COUNTY COUNCIL'S RESPONSE TO CONSULTATION ON THE FOLLOWING DEVELOPMENT PROPOSAL

Application No: 20/00574/F

Proposal: Installation of a standalone Solar PV array, associated infrastructure, grid connection, access and landscaping

Location: Land North Of Hill Farm, Hill Farm Lane, Duns Tew

CONSTRUCTION TRAFFIC ROUTING

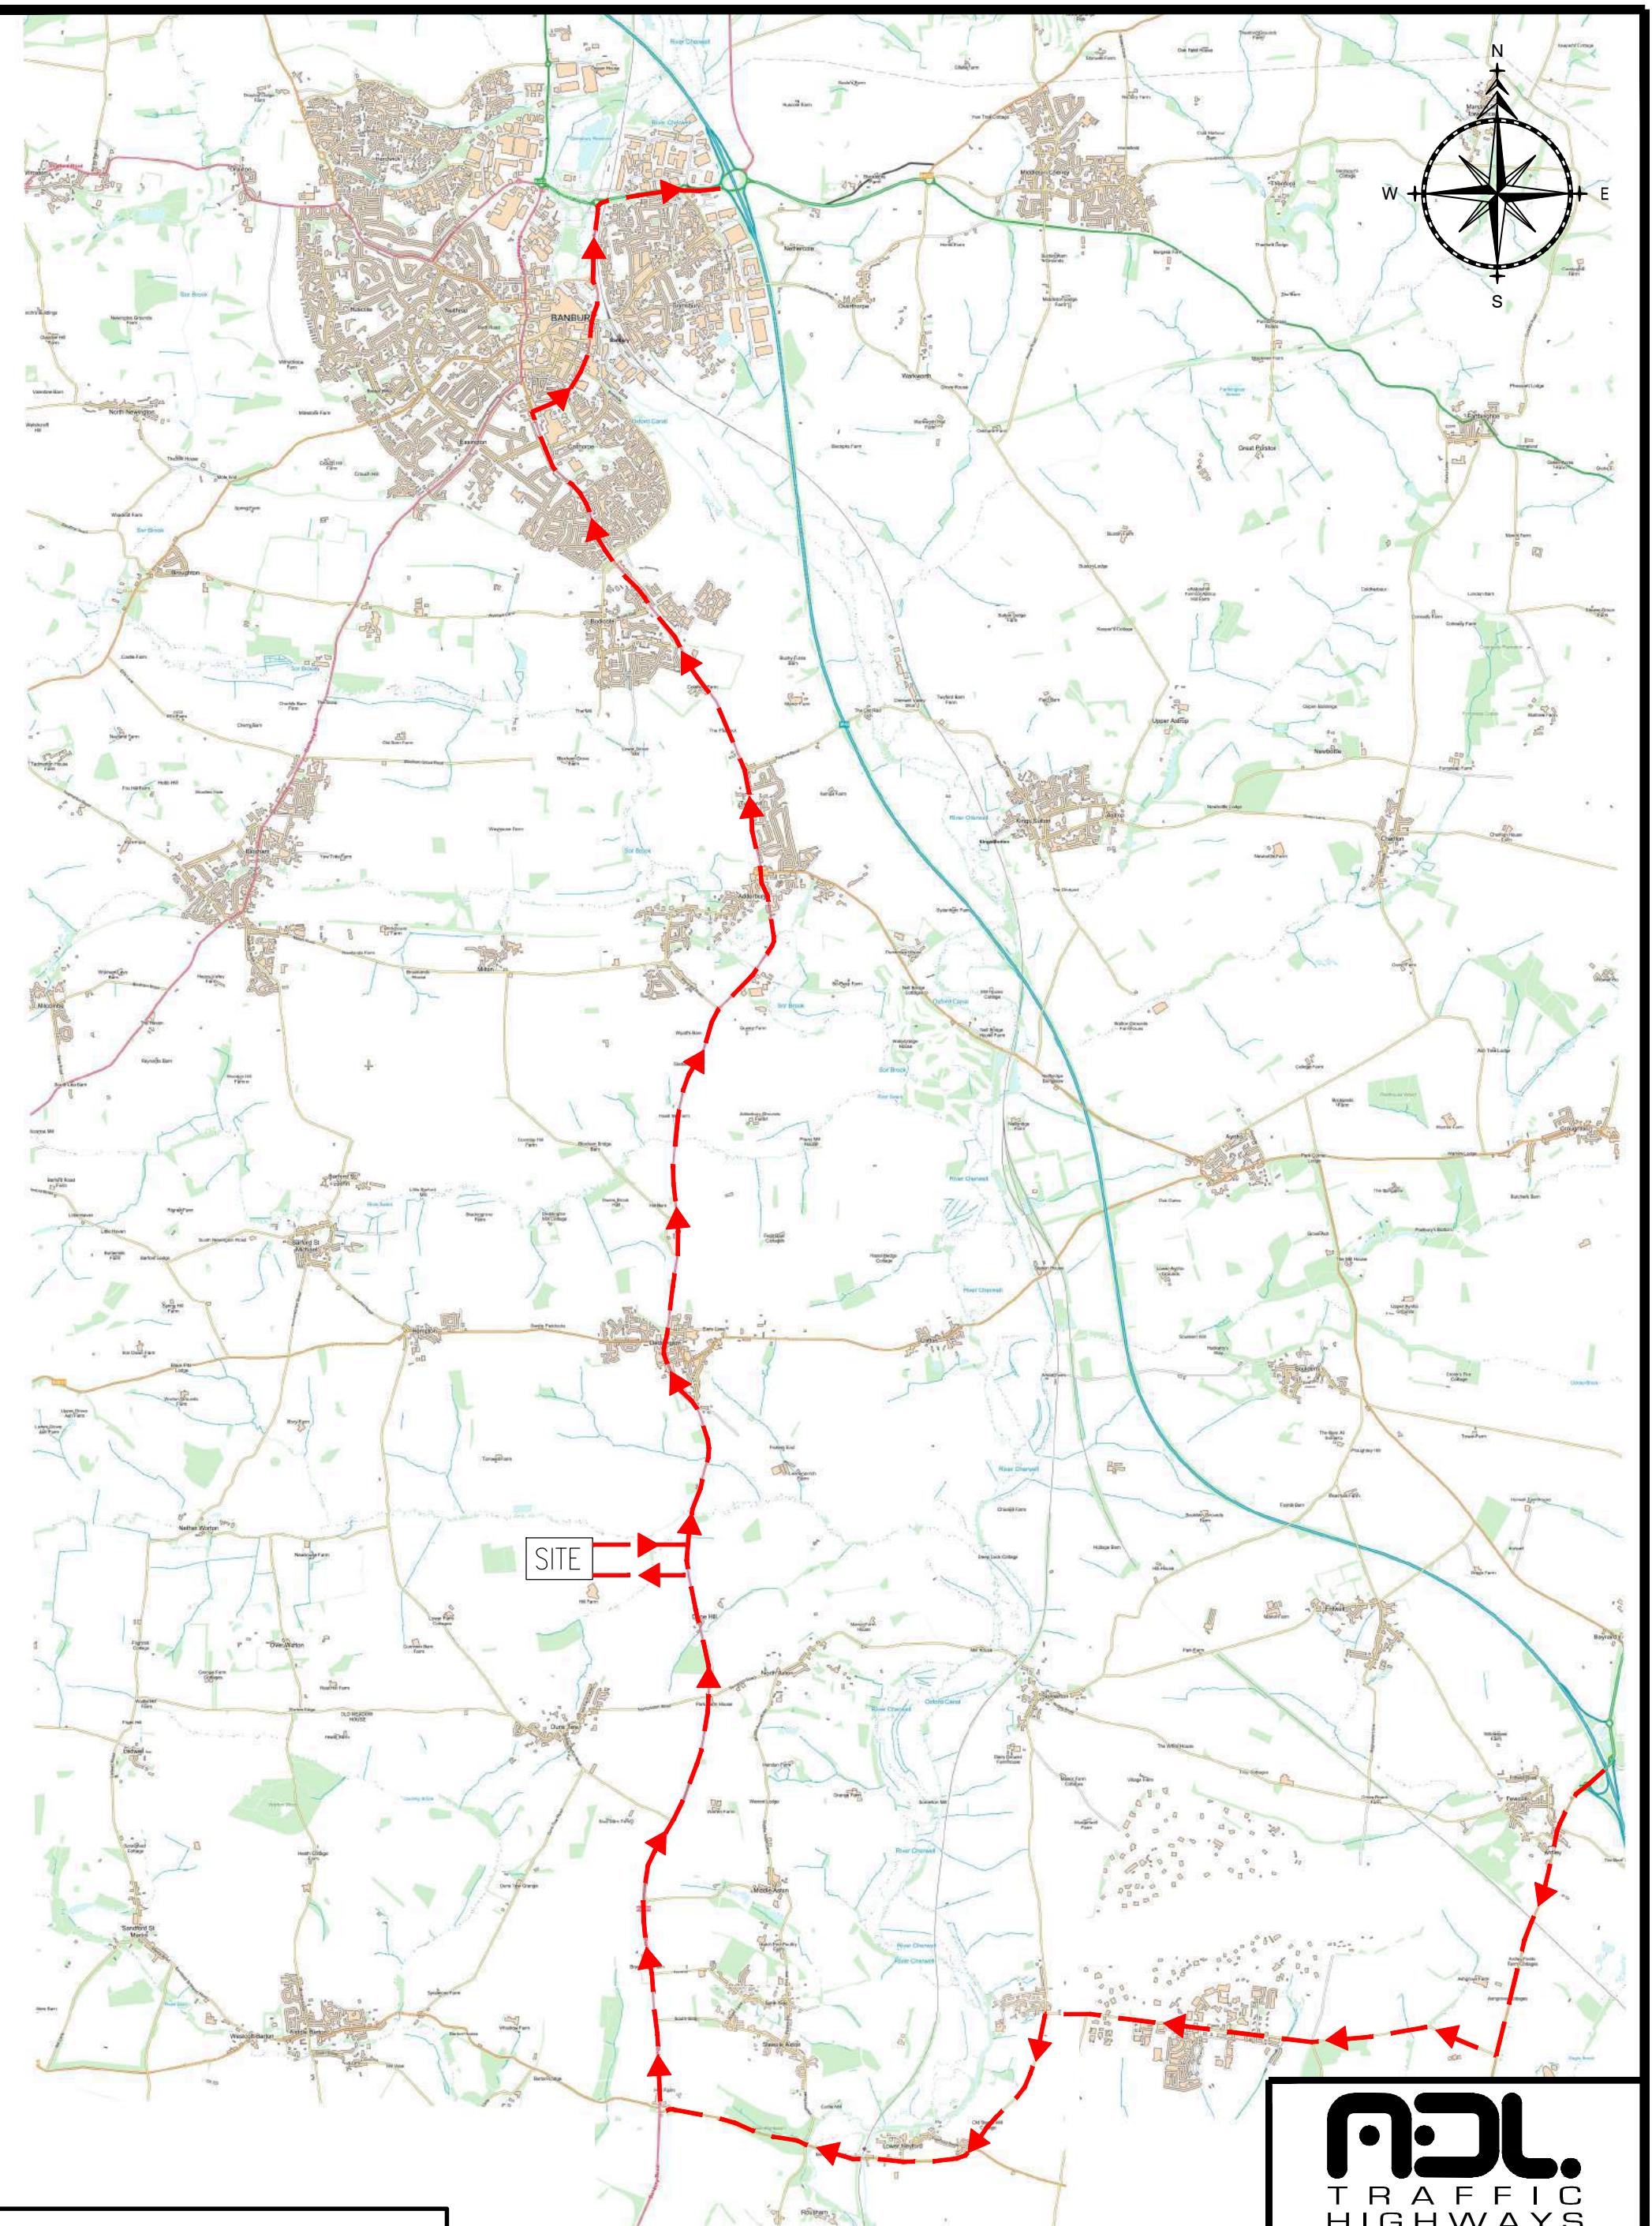
It is agreed that the Construction Traffic Route illustrated in Appendix 3 is the most suitable for accessing the site from the M40. Temporary signage will be required at the west end of Camp Road, Upper Heyford, to direct vehicles to turn left via the B4030 rather than right through Somerton.

Title
Hill Farm, North Aston Road, Duns Tew
Proposed Access Track

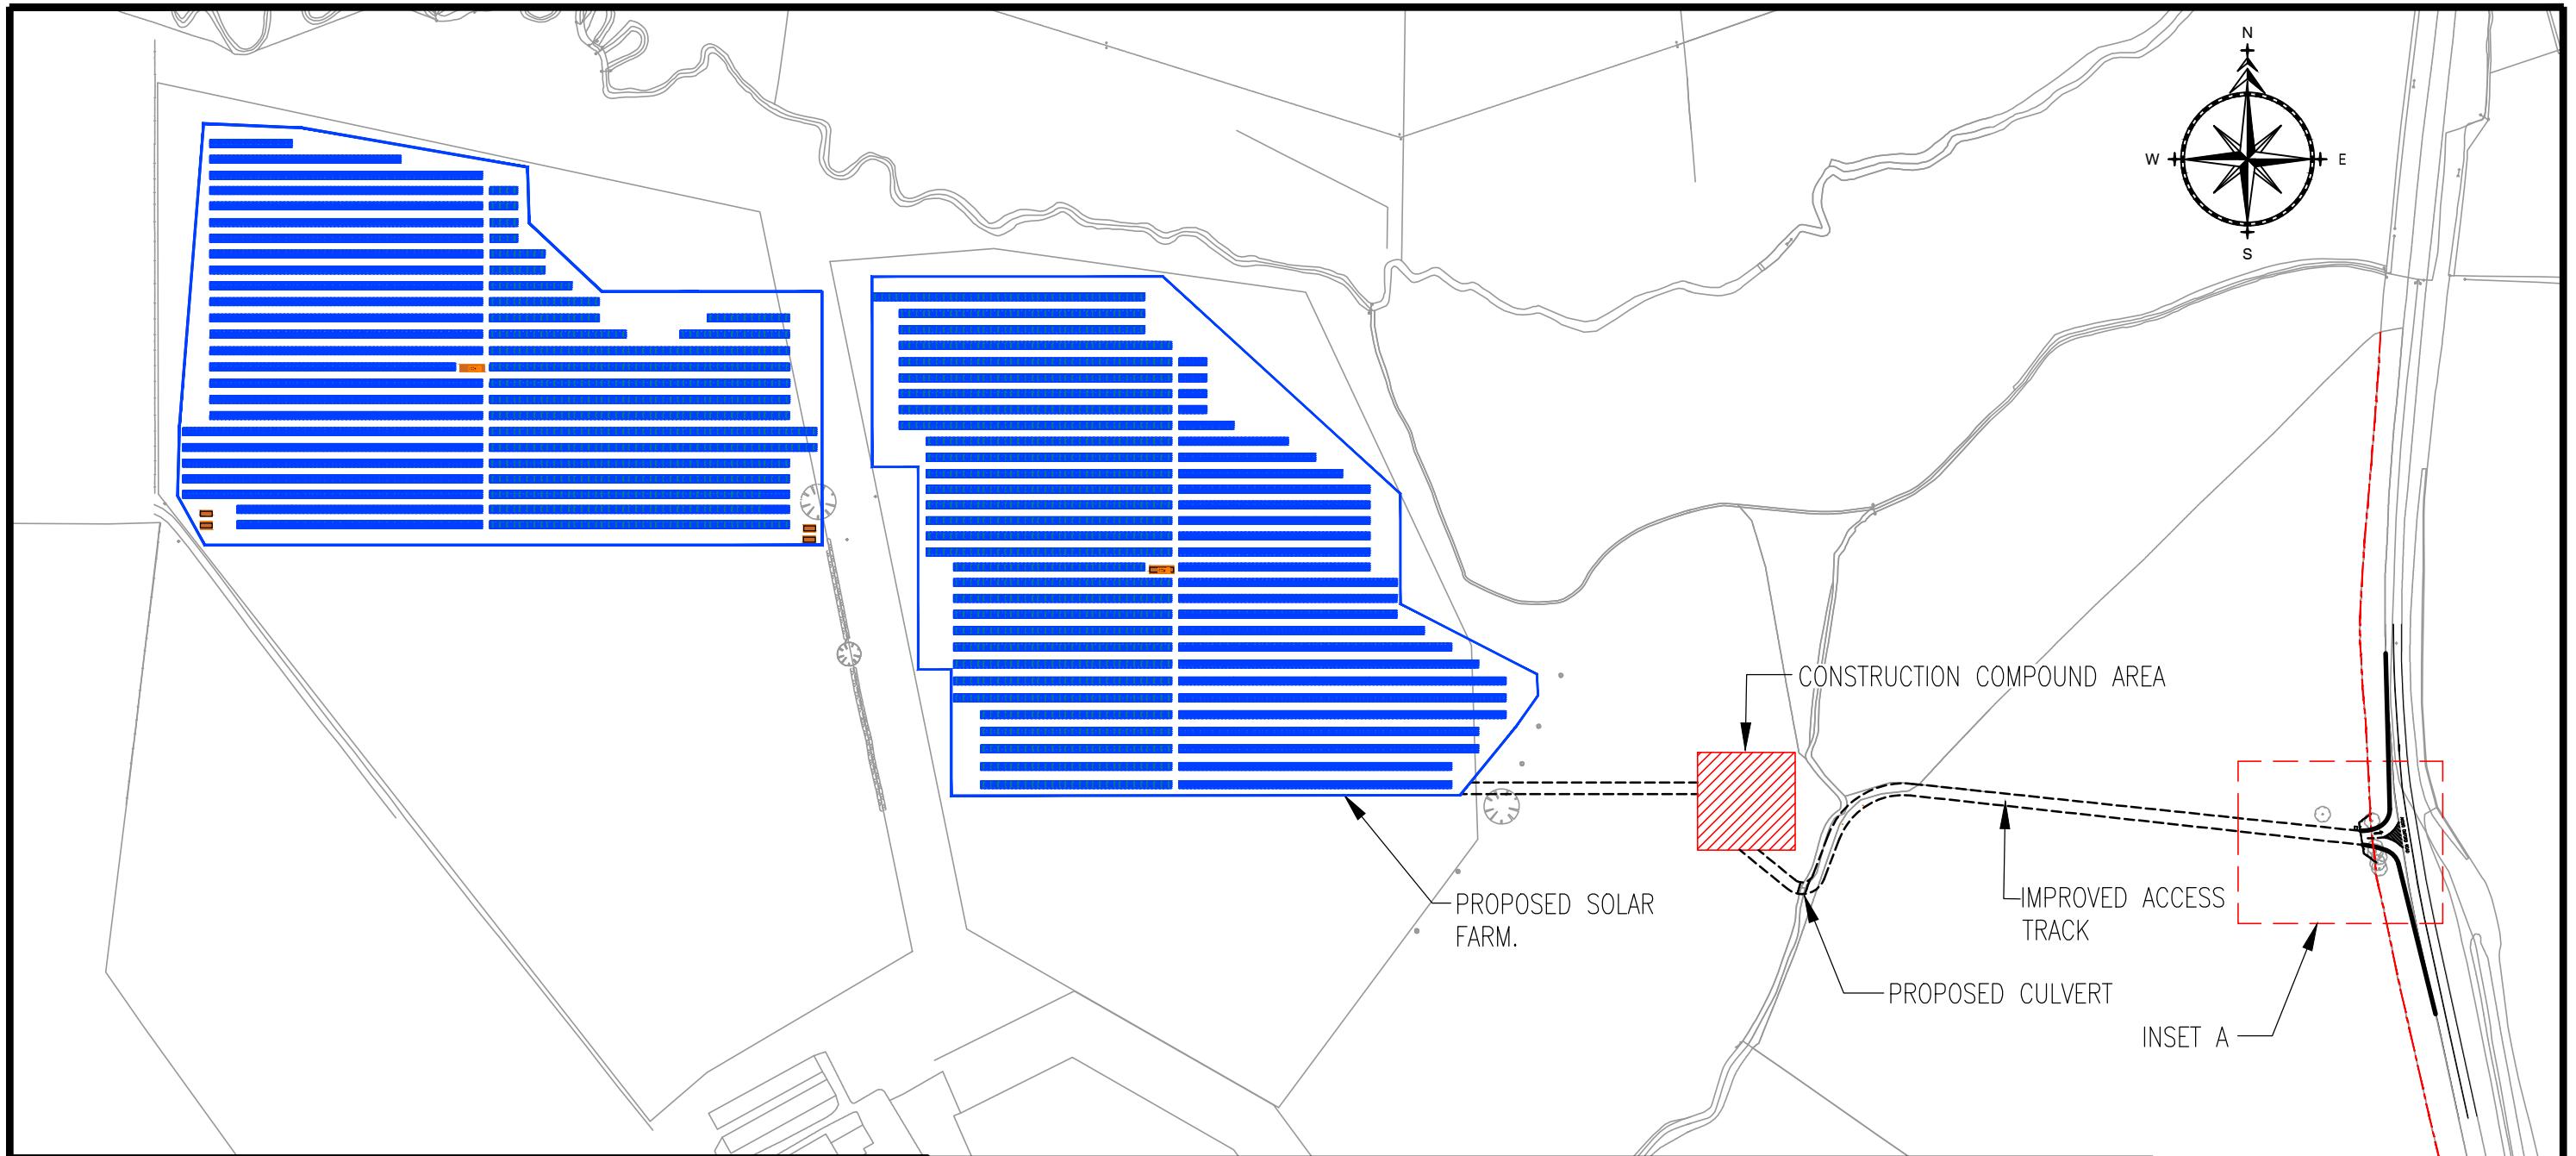
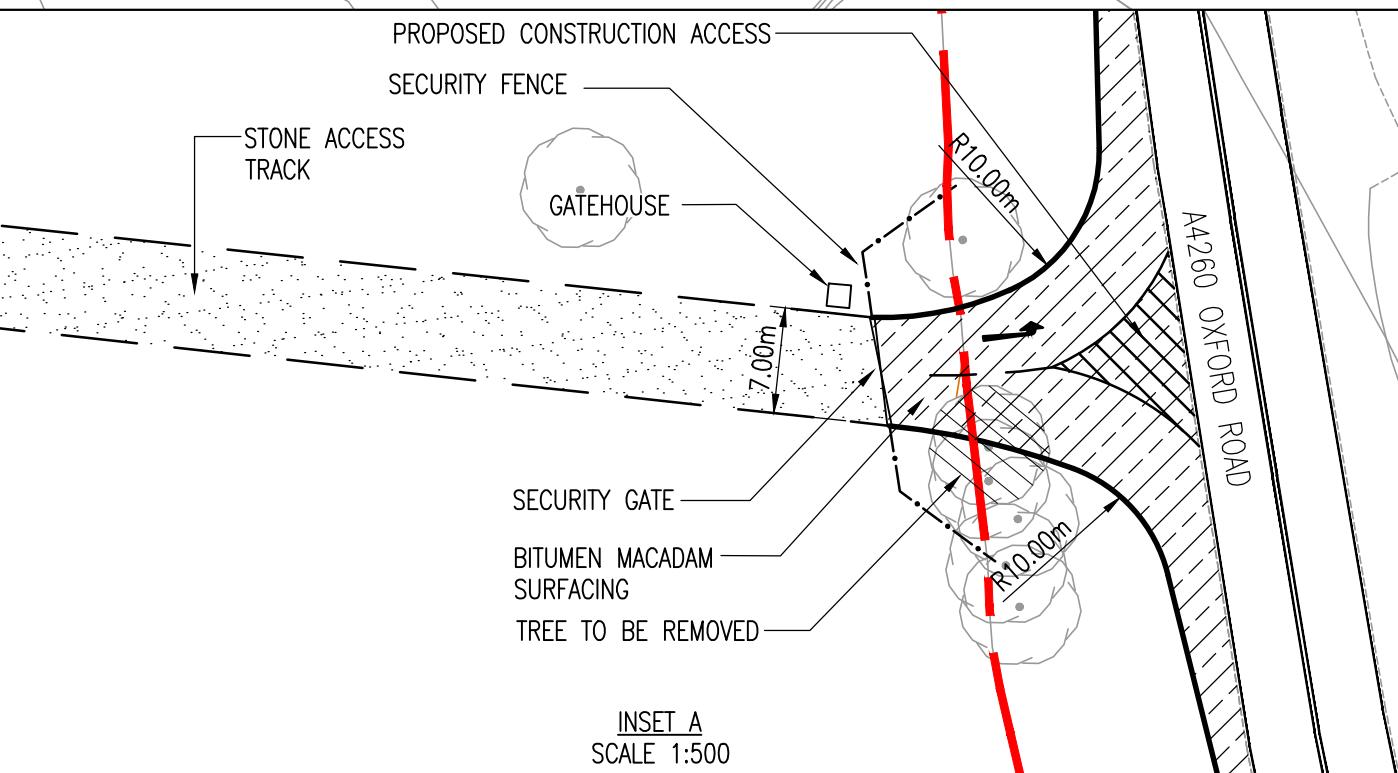
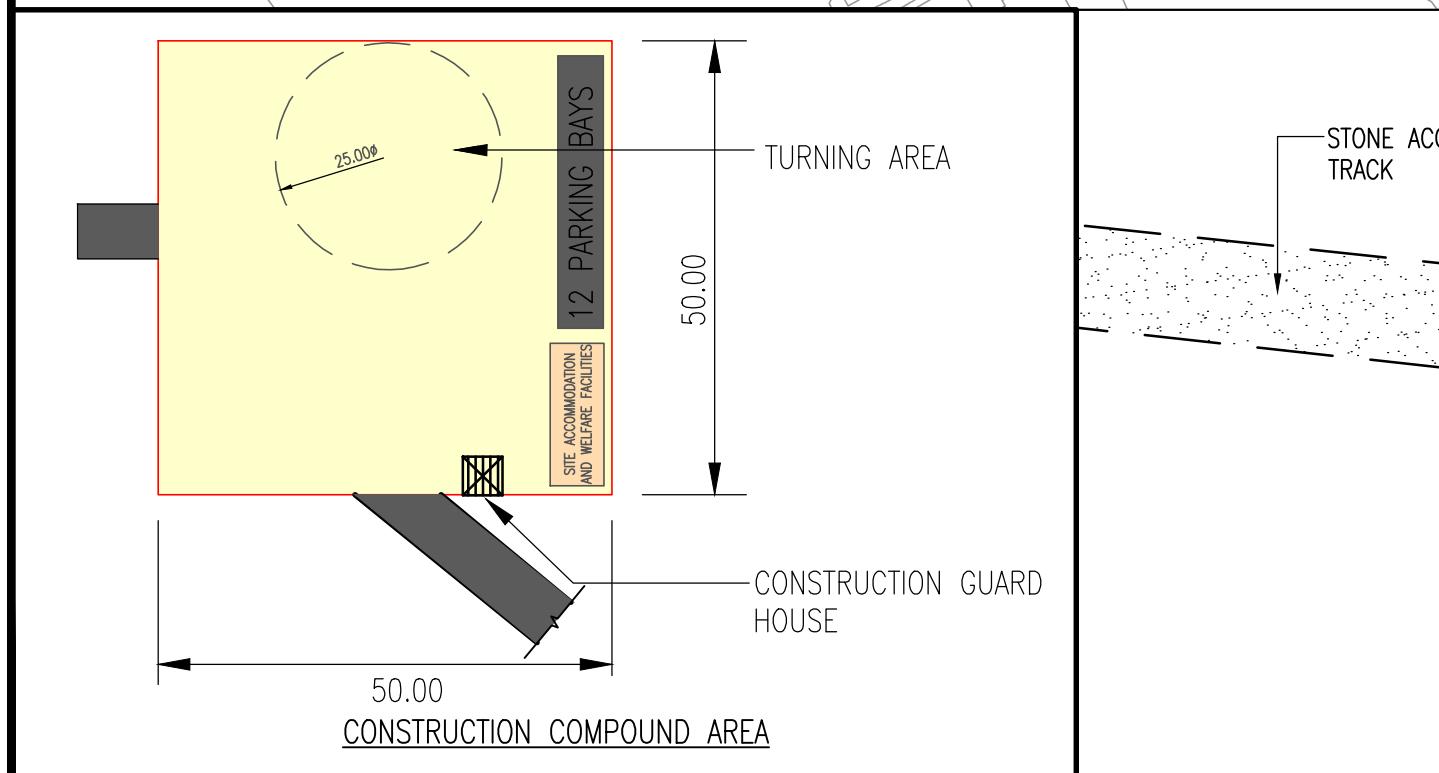
The proposed new access is at the outside of a slight bend in the A4260. There is a significant incline along this section, with a crest to the south.

The drawing in Appendix 6.0 of the CTMP shows a simple priority junction. This is inadequate to accommodate HGVs manoeuvring on and off the fast-moving and heavily trafficked A4260 and is, therefore, a reason for objection as it is contrary to the NPPF which requires "safe and suitable access" (para. 108).

A deceleration lane is necessary on the approach from the south to allow HGVs to pull off the main carriageway before having to proceed very slowly around the radius on to the track. The A4260 has a central double white line to prevent overtaking so, in the absence of a deceleration lane, following vehicles would not be expecting to almost come to a stop while the HGV turned in, and nor would they be able to negotiate around it without crossing to the southbound lane. A temporary speed limit adjacent to the site is likely to have a very limited effect on actual vehicle speeds.

On leaving the site access track there is a significant incline up to the A4260 carriageway. Hence, HGVs will be moving especially slowly as they turn out, which is why an acceleration lane is also necessary to minimise the risk of conflict with other vehicles.

The highway boundary is wide at this location so there appears to be adequate space to accommodate these lanes; however, there are a number of trees within the verge that may affect the layout. Contact should be made with the OCC Highways Tree Team at <u>highwayenquiries@oxfordshire.gov.uk</u> to check which trees can be removed.

- A new access junction from the site access road to the A4260, including acceleration and deceleration lanes
- > Temporary speed limit signage for the duration of the construction period

Prior to the commencement of the development hereby approved, full details of the means of access between the land and the highway, including, position, layout, construction, drainage and vision splays shall be submitted to and approved in writing by the Local Planning Authority. Thereafter, the means of access shall be constructed and retained in accordance with the approved details.
